**Heyford Park, Camp Road, Upper Heyford,  
Bicester, OX25 5HD**

**23/01959/NMA**

**Proposal:** Non-material amendment to 16/02446/F - amended elevation plans for 7 plots (plots 630-632, 634-635 & 646-647)

Drawing Title:
HOUSE TYPE 3D GROUND, FIRST, SECOND FLOOR PLANS

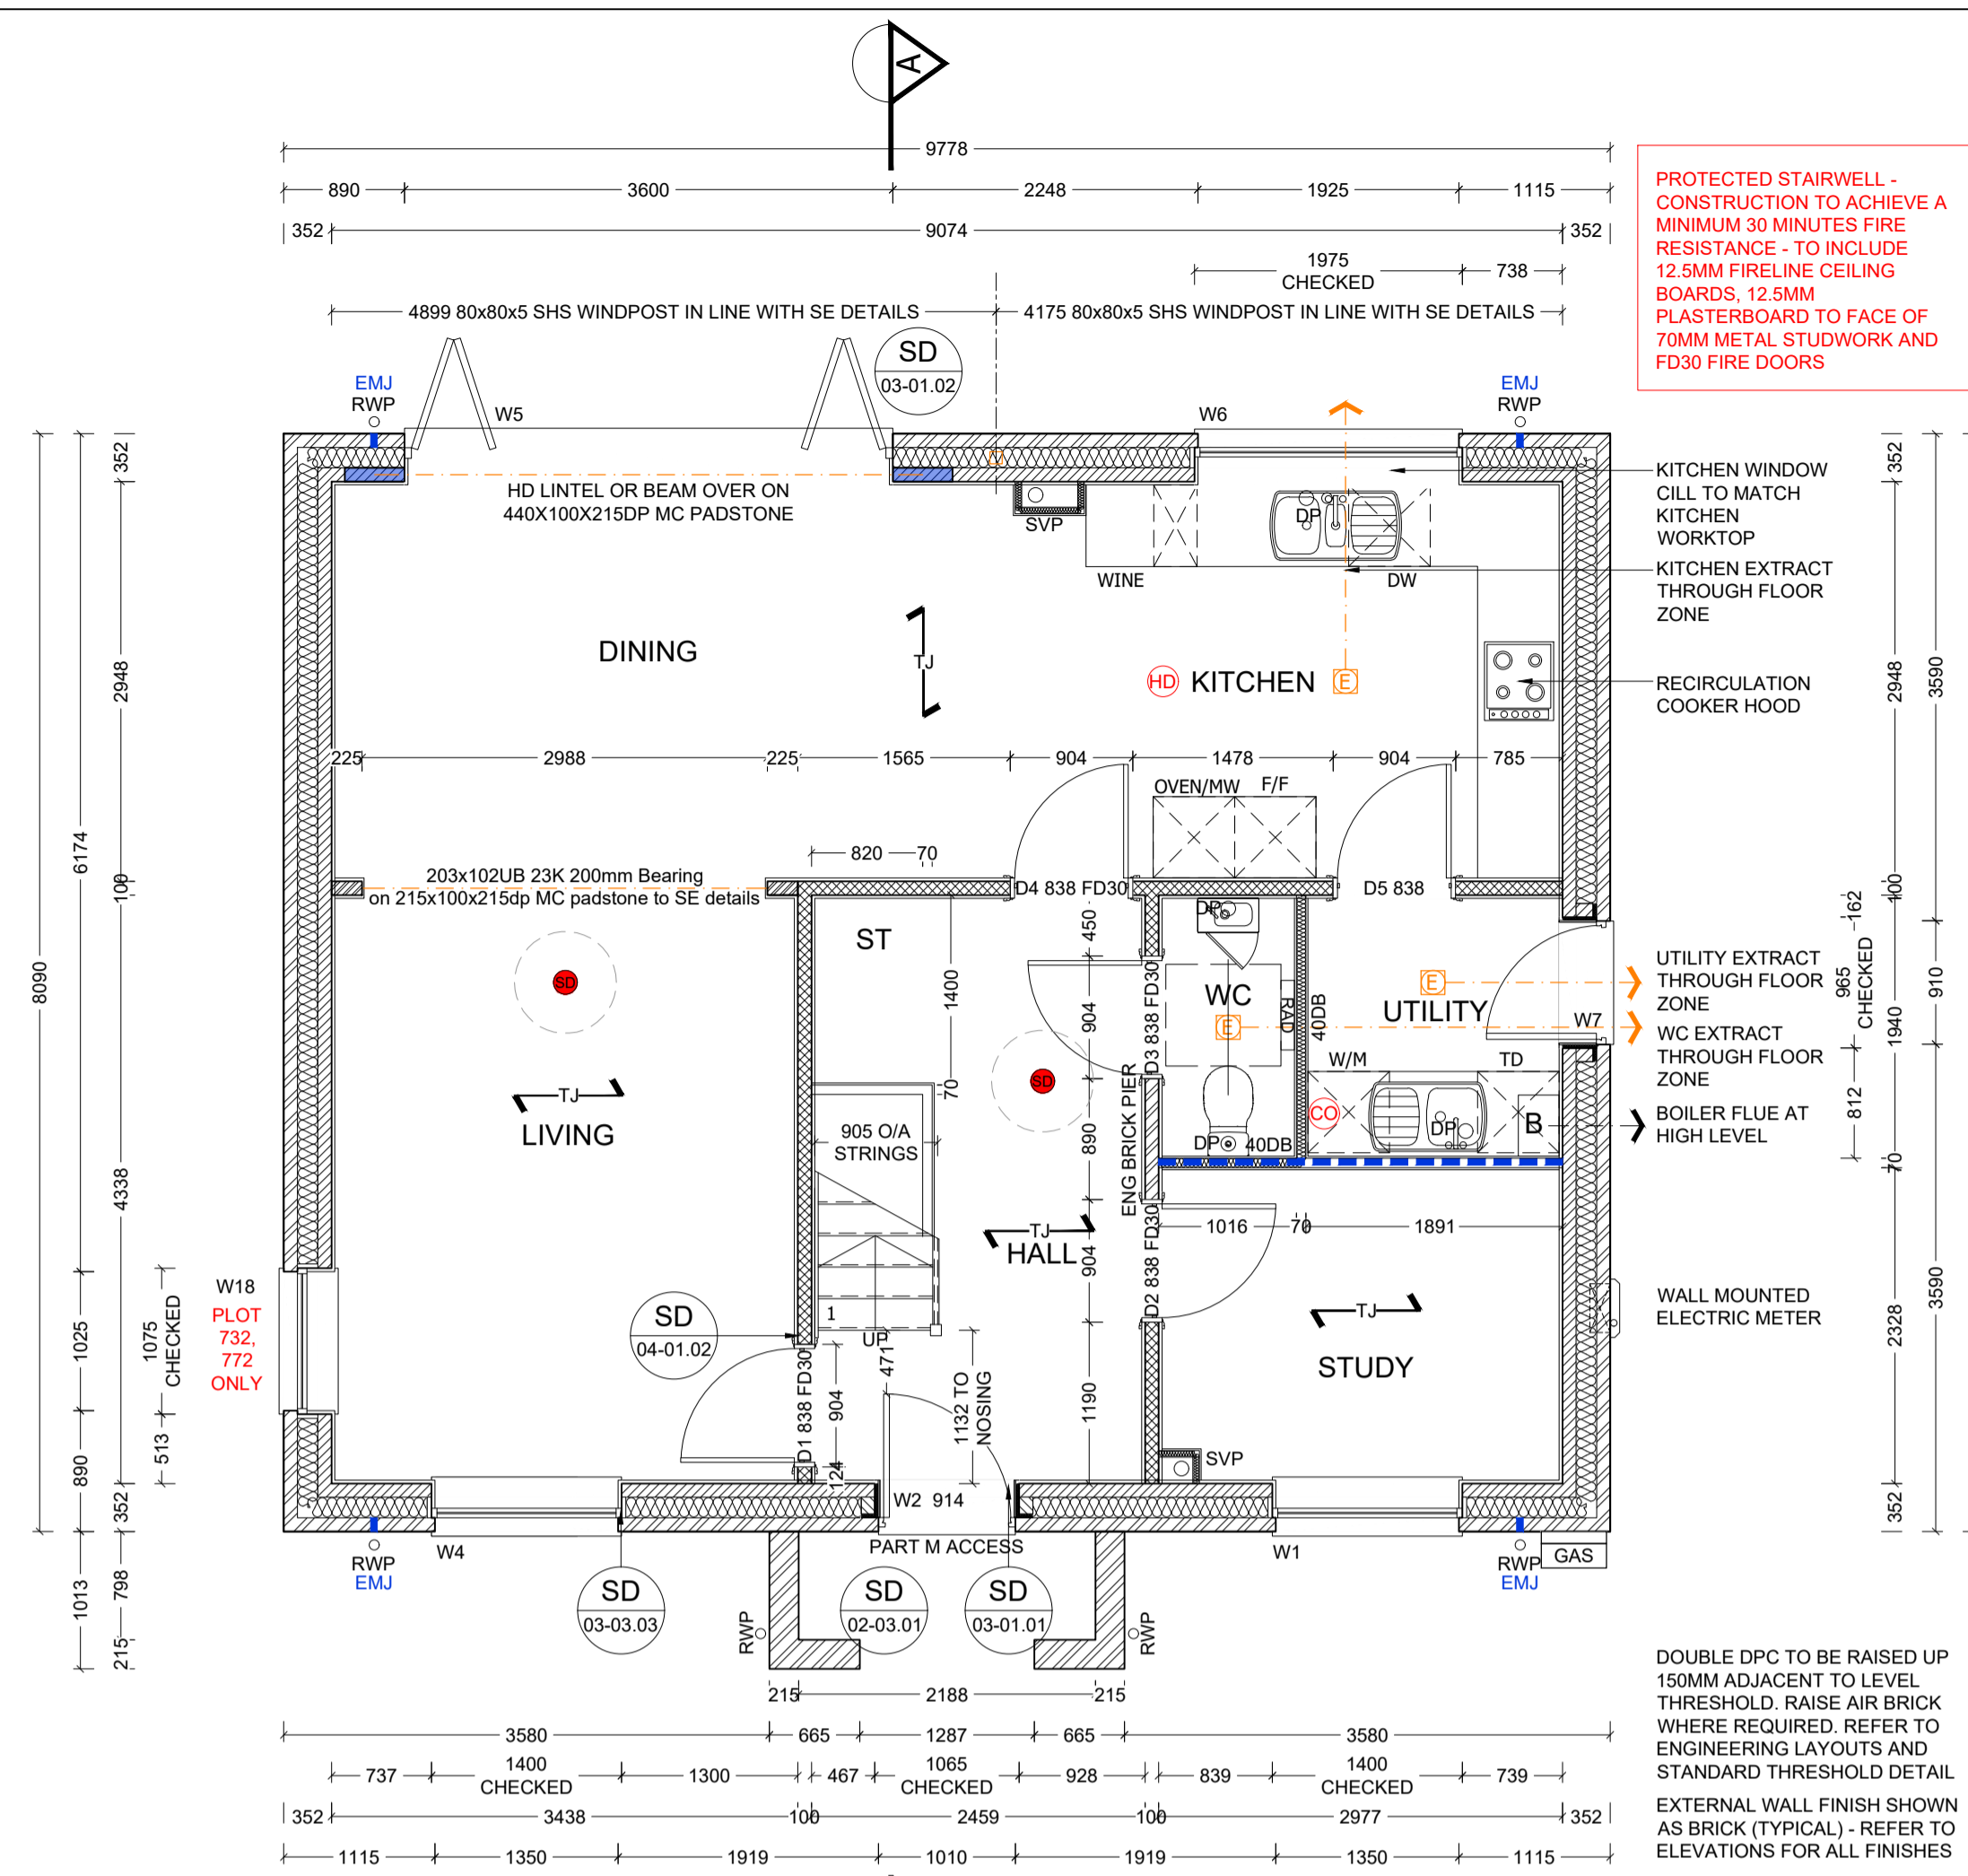
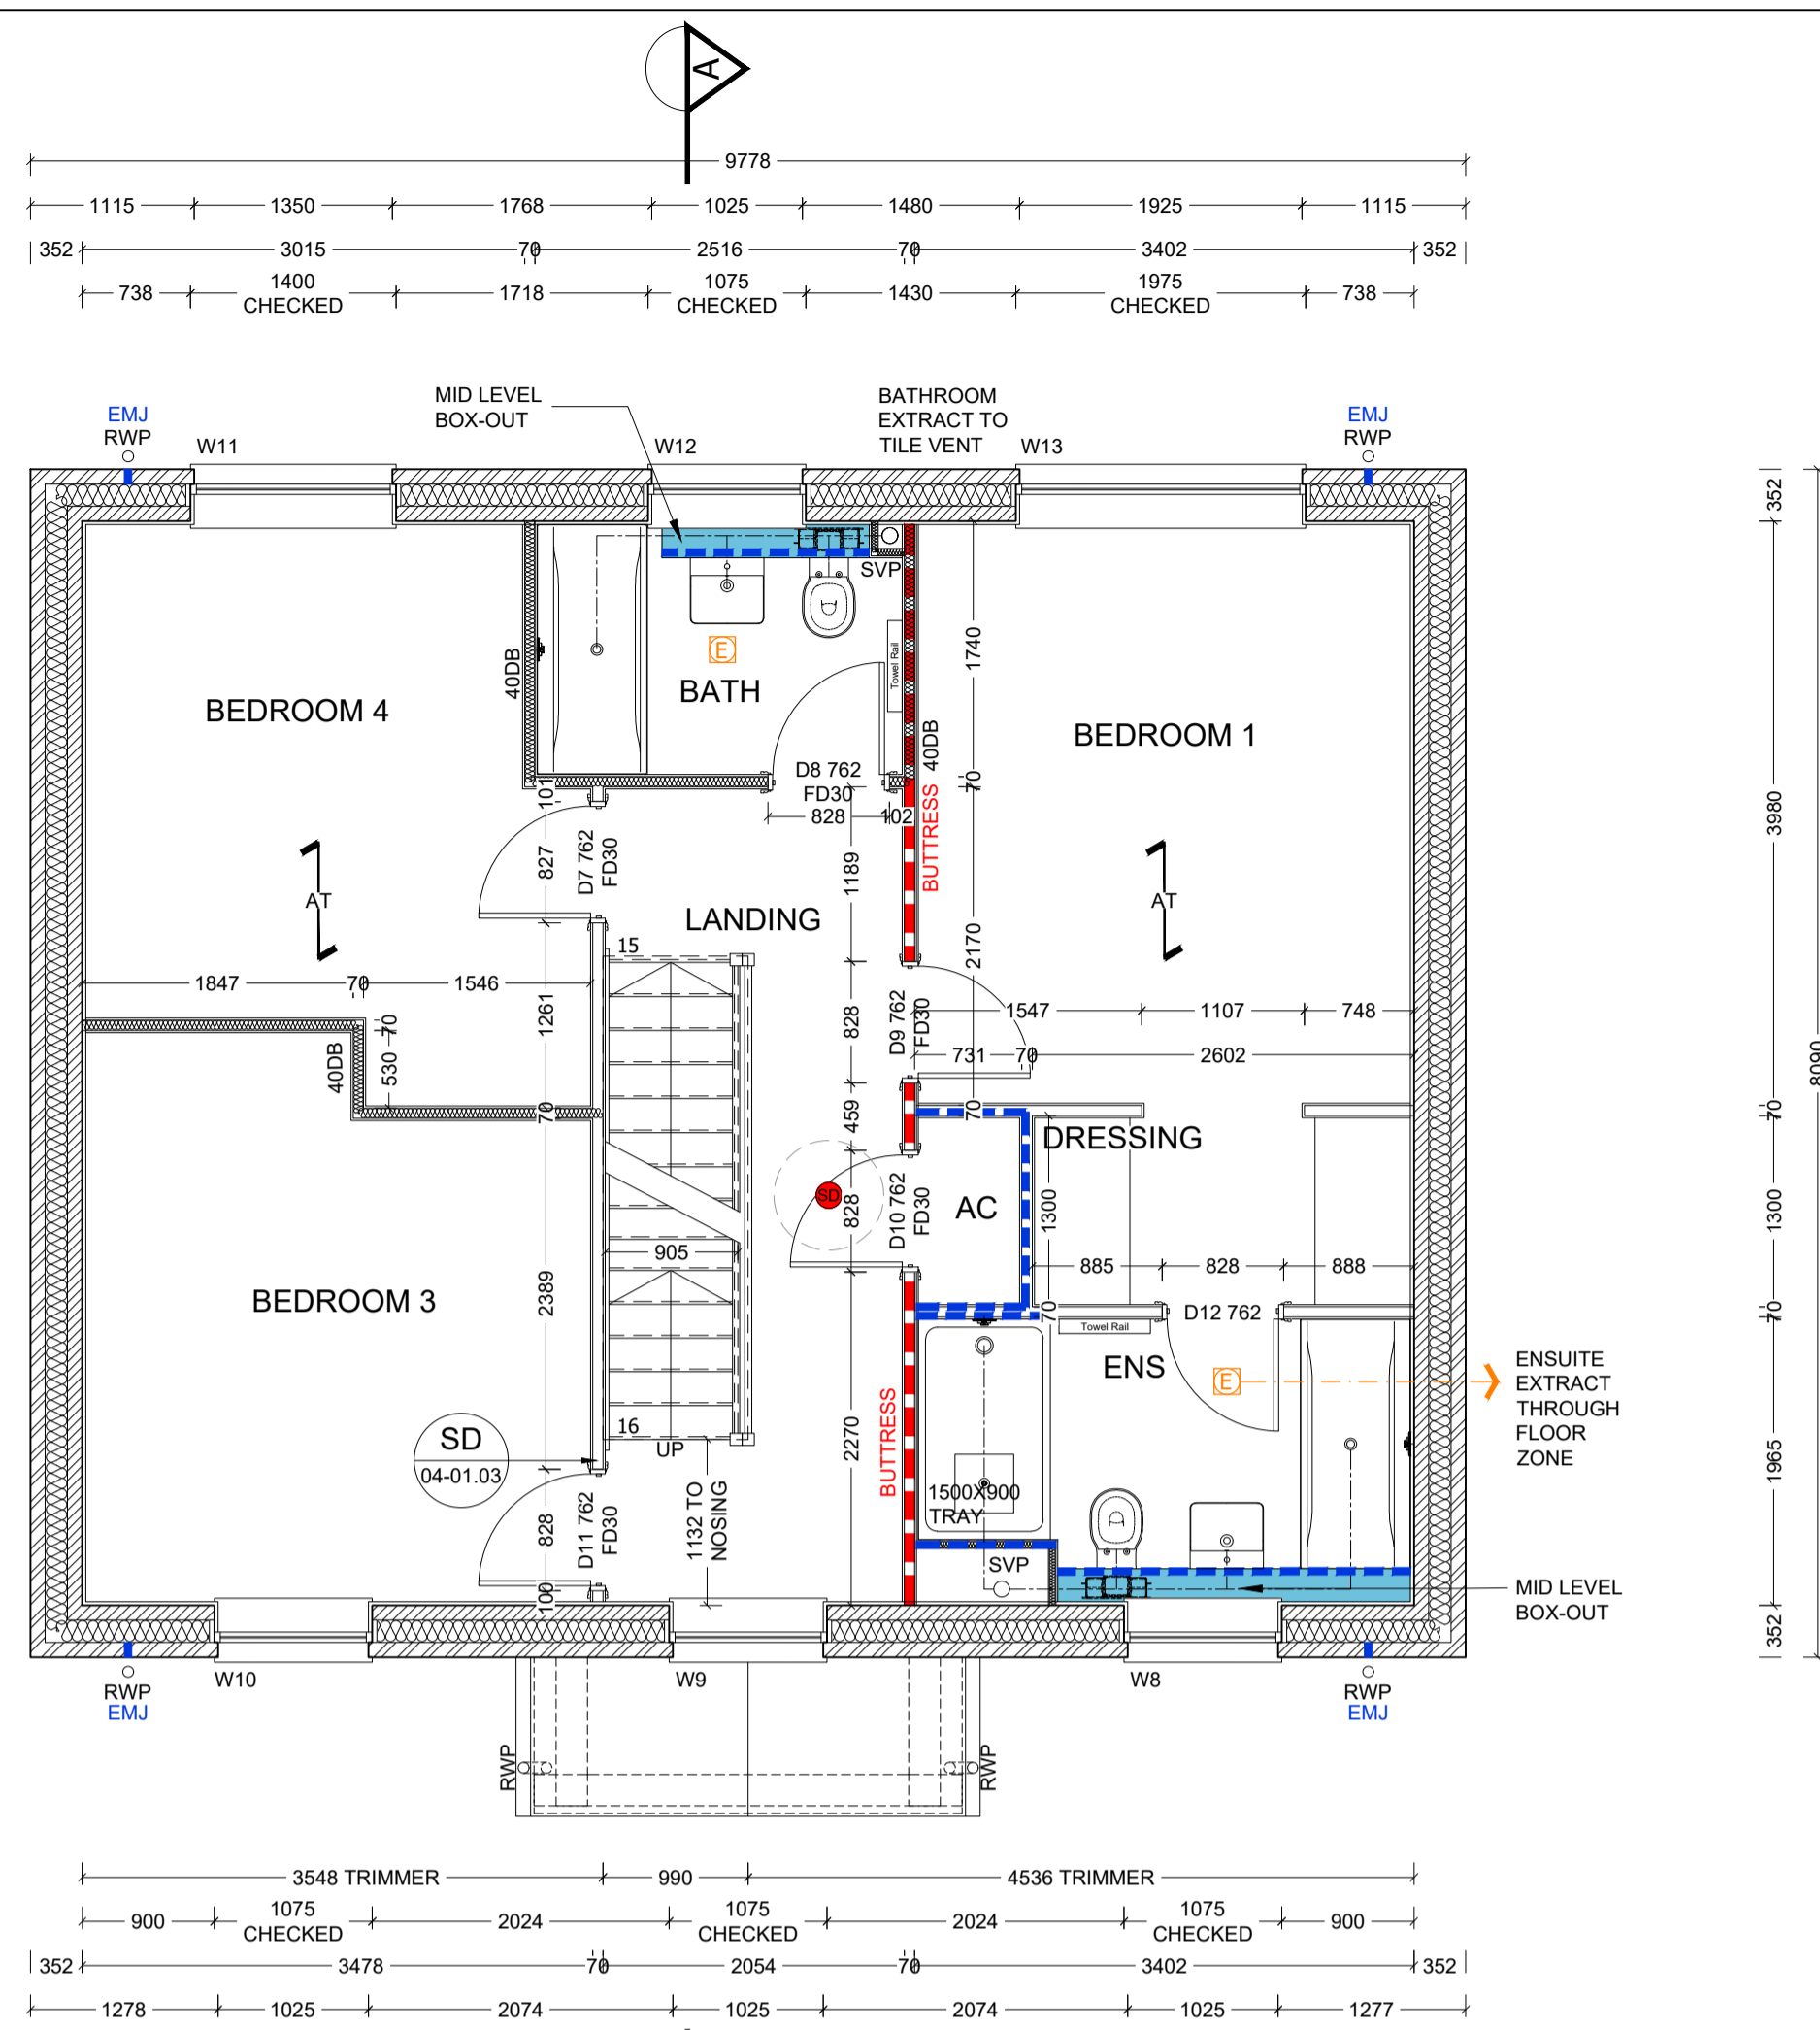
#### House Type 3D – Plot nos.630 and 631

- Brick built extruded porch added to front entrance;
- Elevational openings amended to better the symmetry of the façade;
- Living room window (W4) reduced by one pane to allow centralisation of porch and balancing of façade;
- 2nd floor shower room svp vented to roof to avoid need for destructive access.
